**KIRKLEES METROPOLITAN COUNCIL
INVESTMENT & REGENERATION SERVICE**

**DELEGATED DECISION TO DETERMINE APPLICATIONS FOR LISTED
BUILDING CONSENT**

Reference No: 2021/65/90593/W

Site Address: 88, Handel Street, Golcar, Huddersfield, HD7 4AE

PROPOSED GROUND FLOOR PLAN
SCALE 1:50

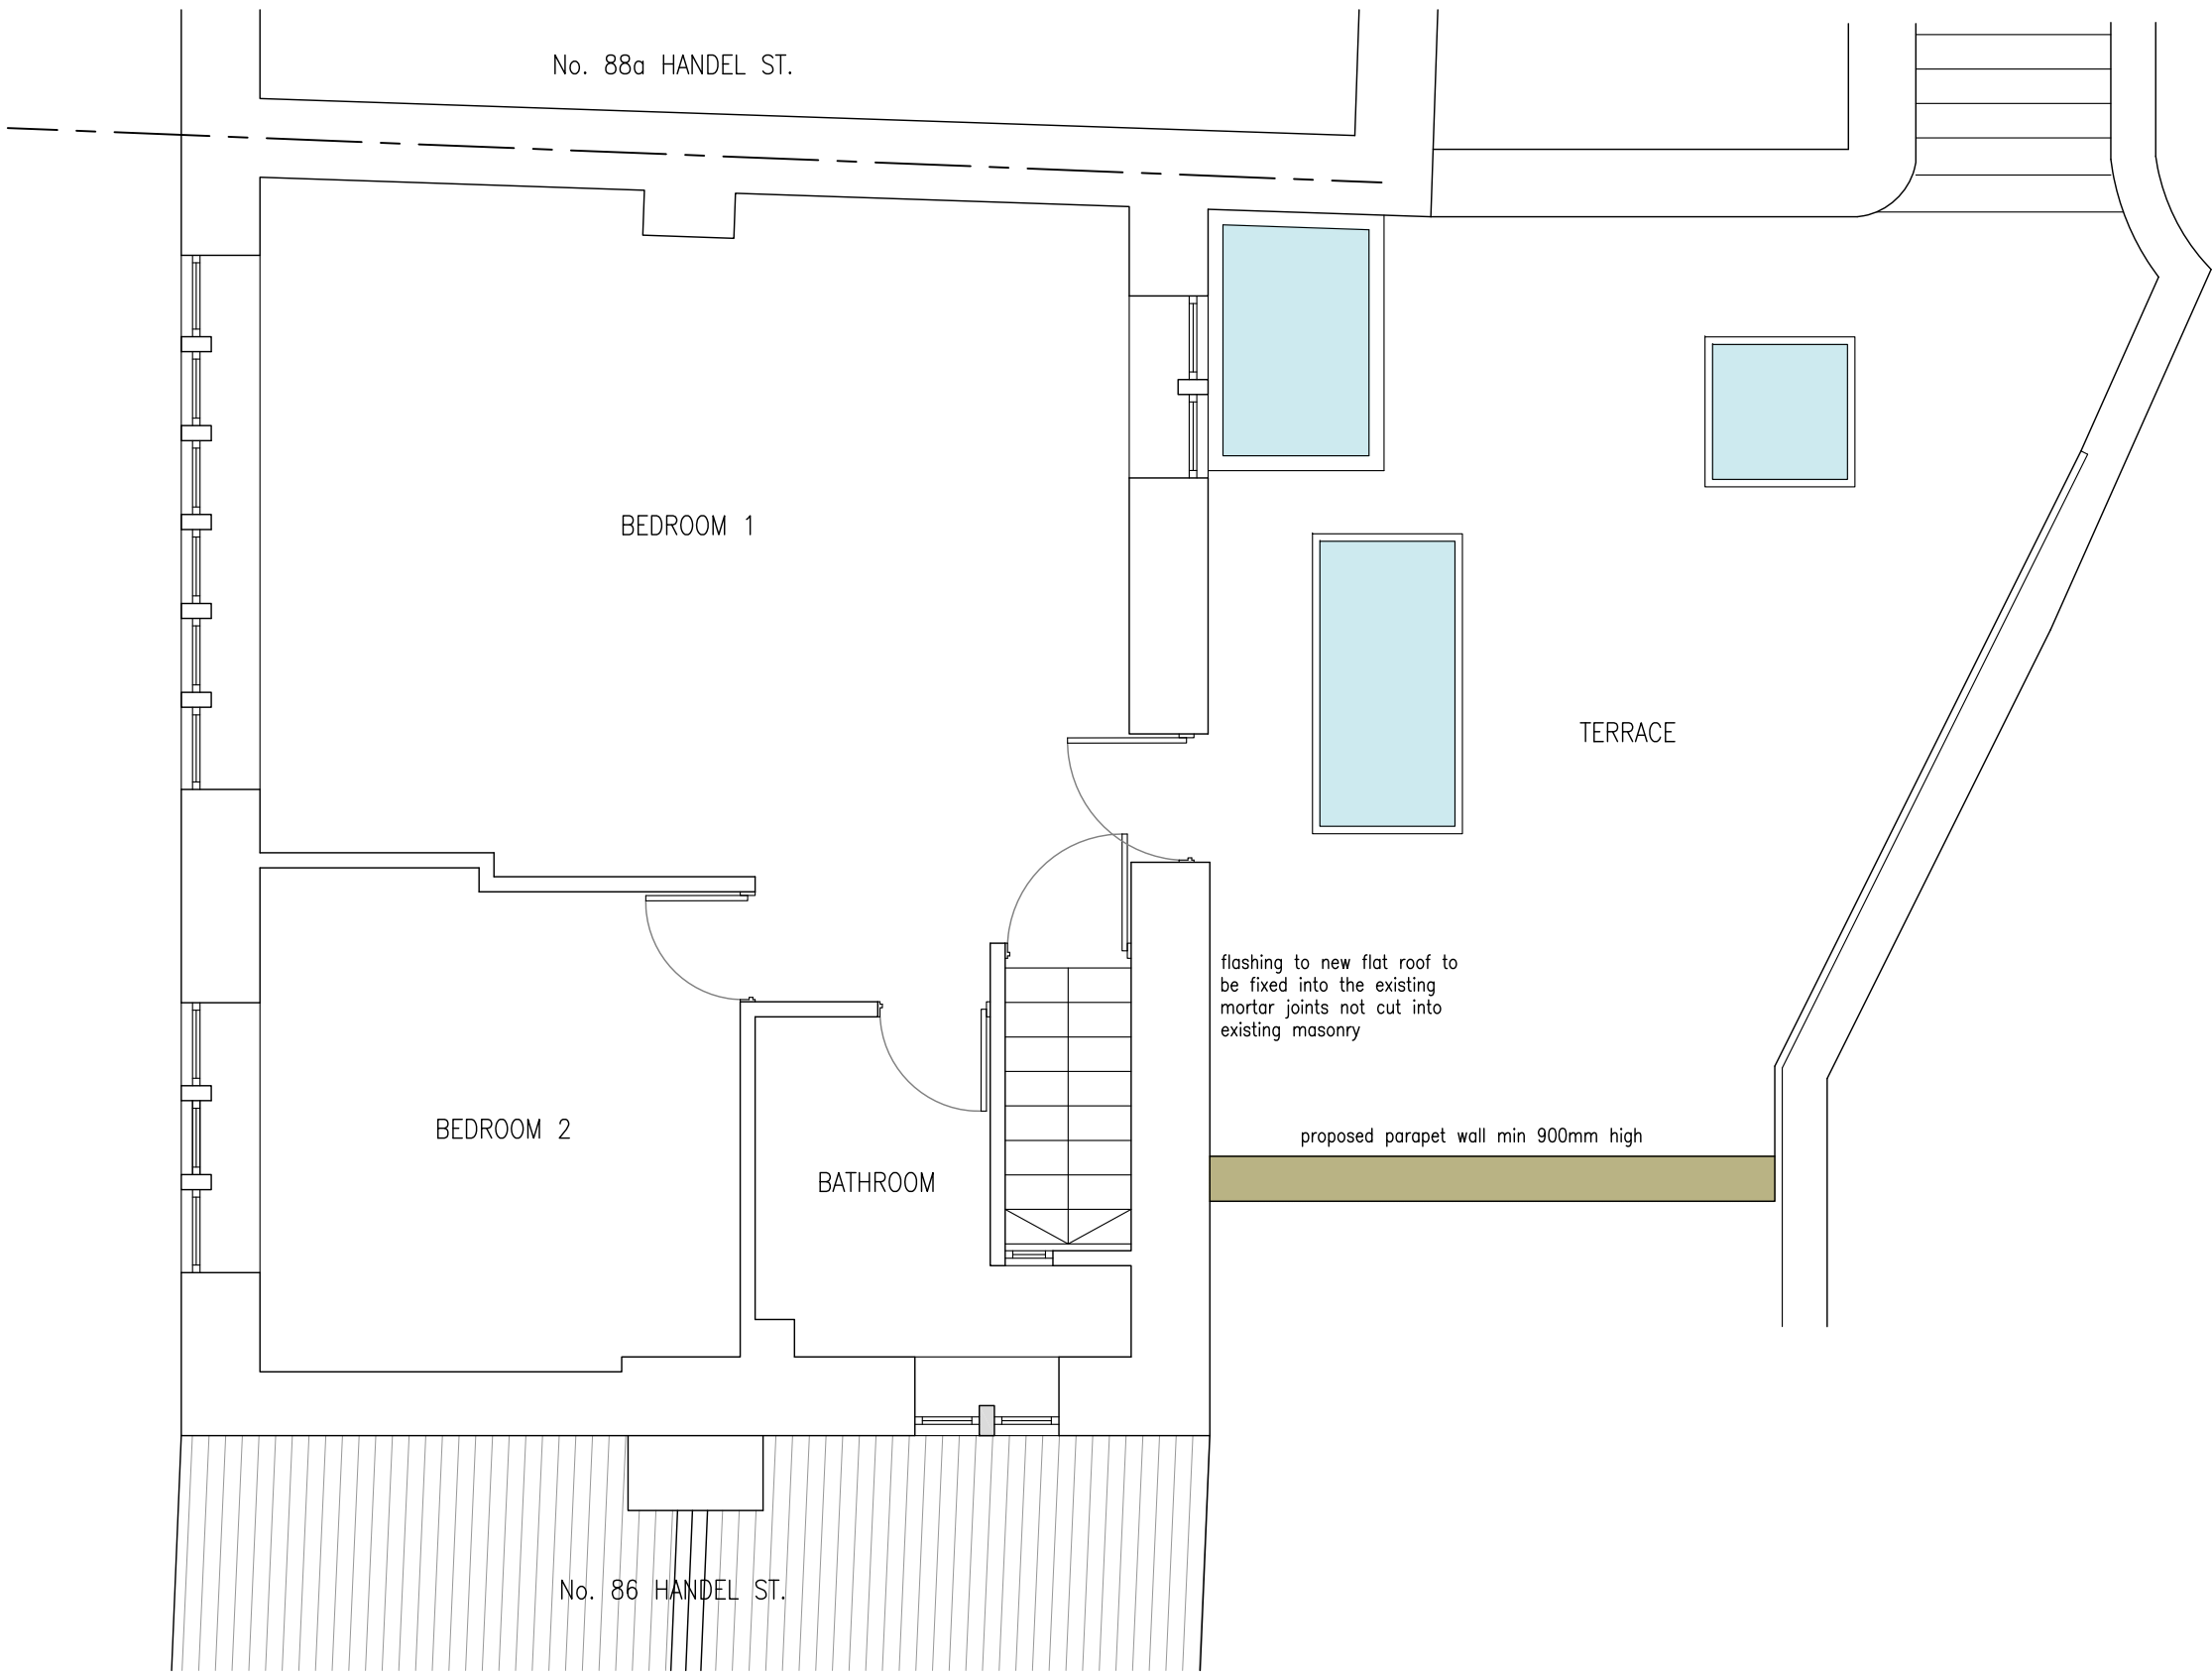
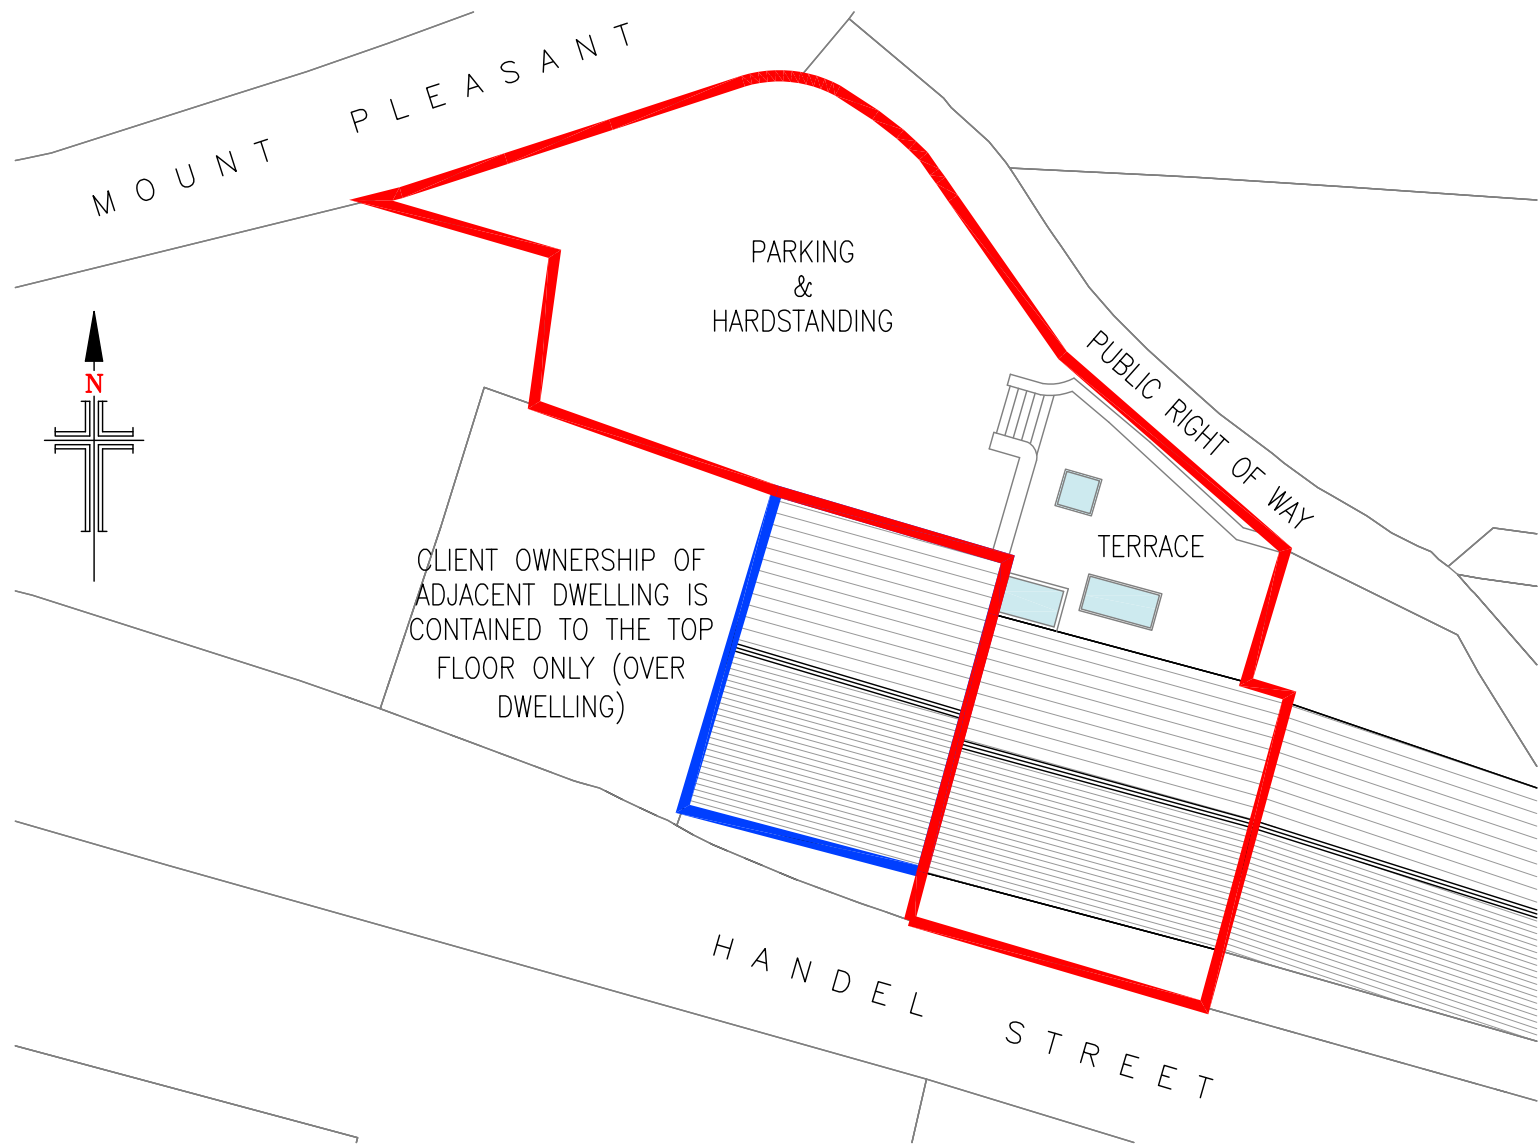
The case officer considered the application on review and sought amendments after the Conservation & Design Officer's consultation response

to have a parapet roof detail and wrought iron railings and to receive more in-depth detail on the ventilation for the lightwell for avoidance of condensation and damage to the Listed Buildings.

Two structural openings are proposed from the house into the new extension, one on the ground floor where no historic openings will be disturbed, and access on the first floor where a previously blocked up opening will be reinstated to create access into the extension; the relocation of a doorway proposed at first floor level to create en-suite was not of concern to the Conservation & Design Officer as it is likely to be a later partition.

An internal lightwell is proposed to provide borrowed light to the en-suite and gym and which is acceptable as the mullioned windows of the house is retained within this space. A low level roof ventilator adjacent to the roof light in matt black would provide ventilation to the void with dimensions of 300mm in diameter and flush mounted which was reviewed by the Conservation & Design Officer and found acceptable for reducing risk of condensation to the host dwelling.
